# Summary of Comments on 1801-222-SUB1- PLANS\_review.pdf

**Project:**  
 TALERMAN SIMON RESIDENCE  
 387 WEST MERZER WAY  
 MERZER ISLAND, WI 53840

**Sheet Title:**  
 CIVIL SITEWORK PLAN

**Sheet No:**  
**C1.1**

**CONSTRUCTION NOTES:**

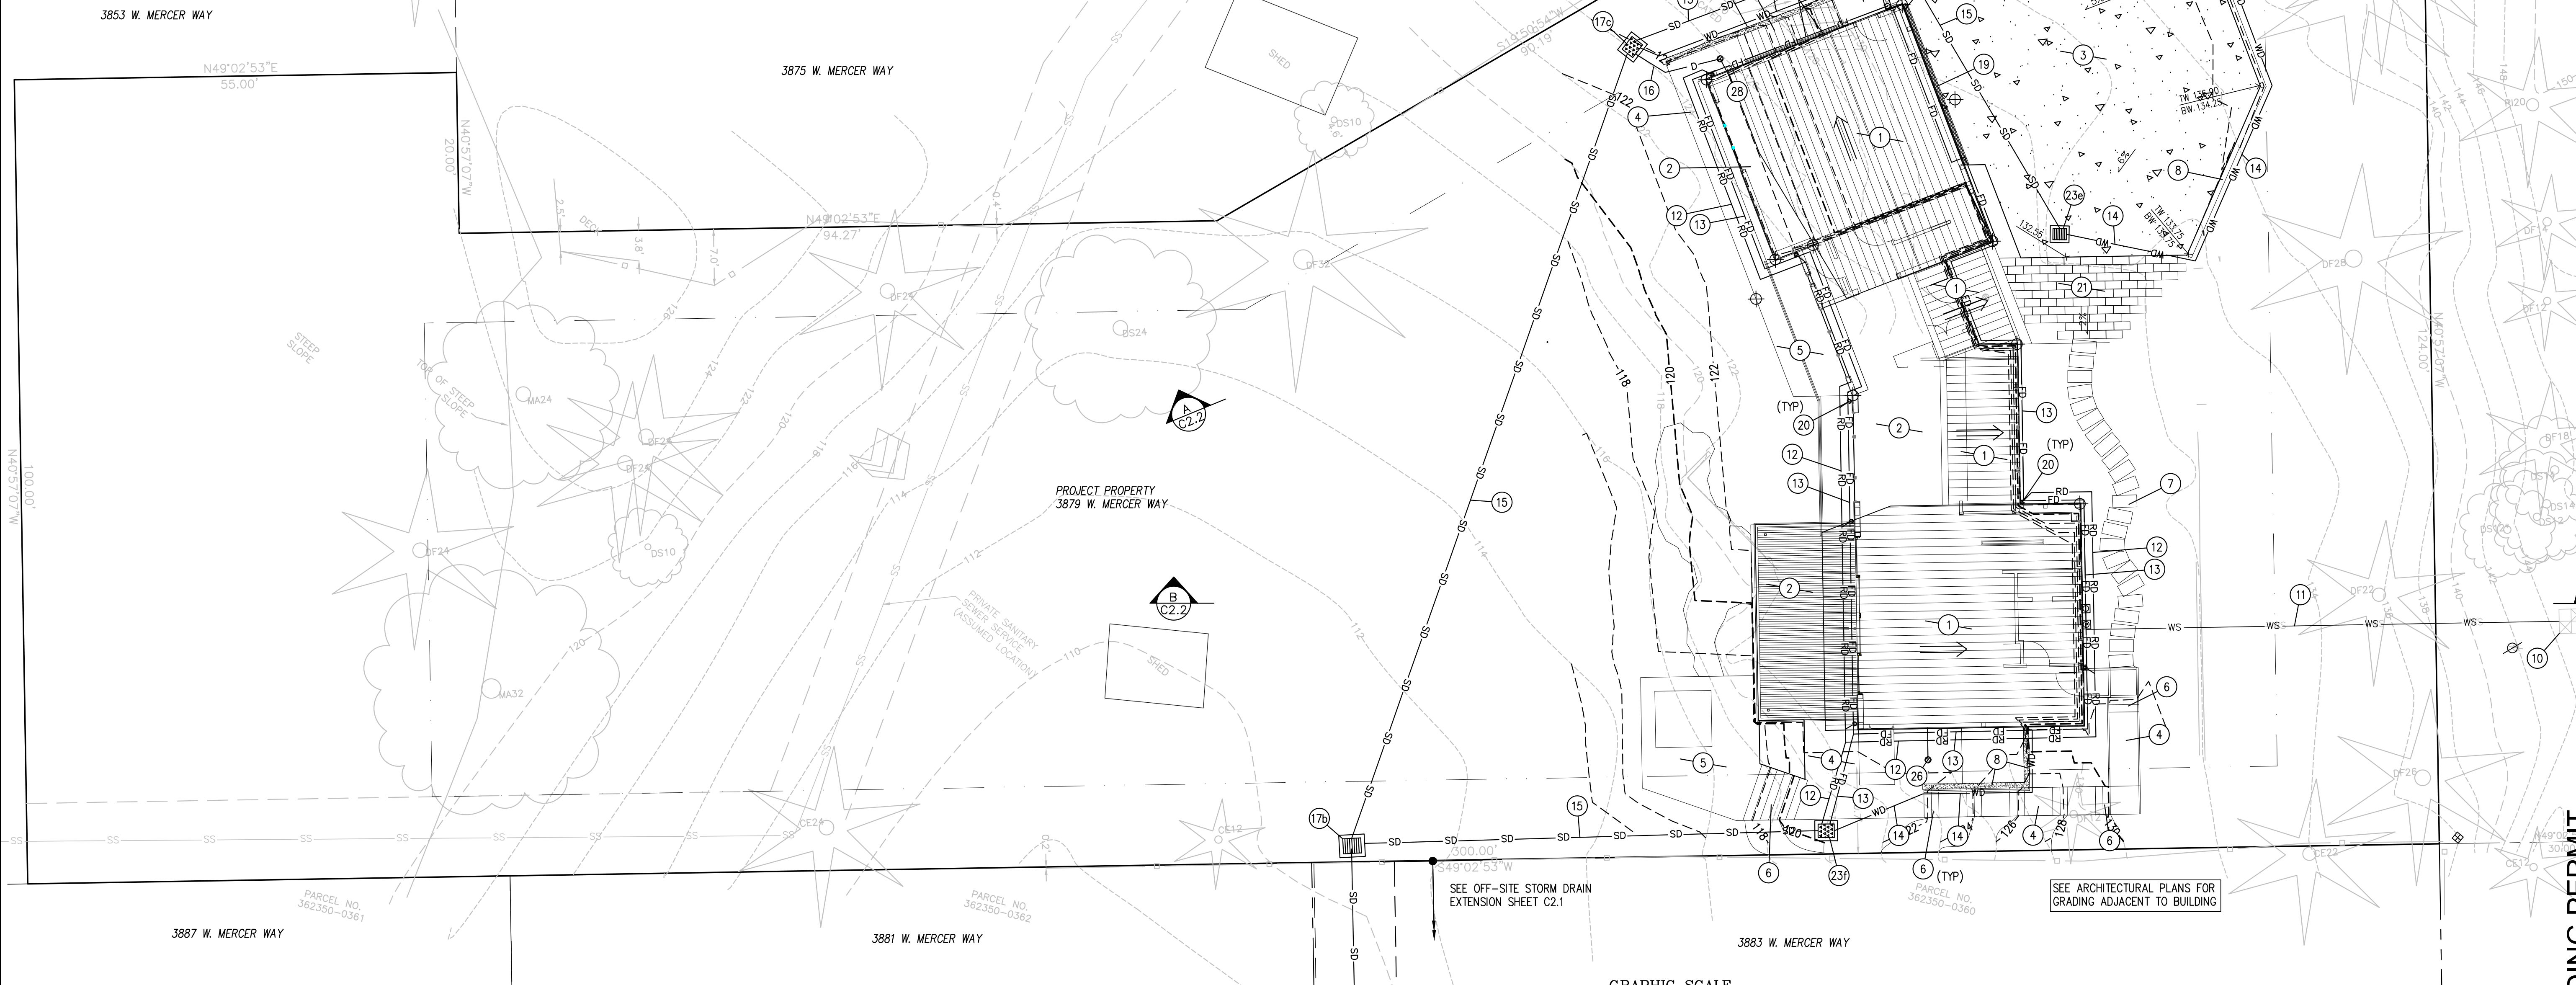
Number: 1      Author: Tree Review (john.kenney@mercergov.org)      Subject: Sticky Note      Date: 11/13/2018 8:11:10 AM  
2. All replacement trees to be at least 10' apart from each other, existing trees and structures. Please call out.

1. Trees on adjacent property are not included in the Arborist report. Arborist needs to provide information on these trees including proposed tree for removal. Minimum limits of disturbance for these trees need to be provided. Arborist needs to review and comment on current plans and new driveway expansion and rock wall.  
Civil sheet needs to be updated with Arborist provided tree numbers.

3. Tunnel/bore WS line within dripline of saved tree (trees to be numbered on this sheet). Call this out. Or move WS line outside saved trees dripline.
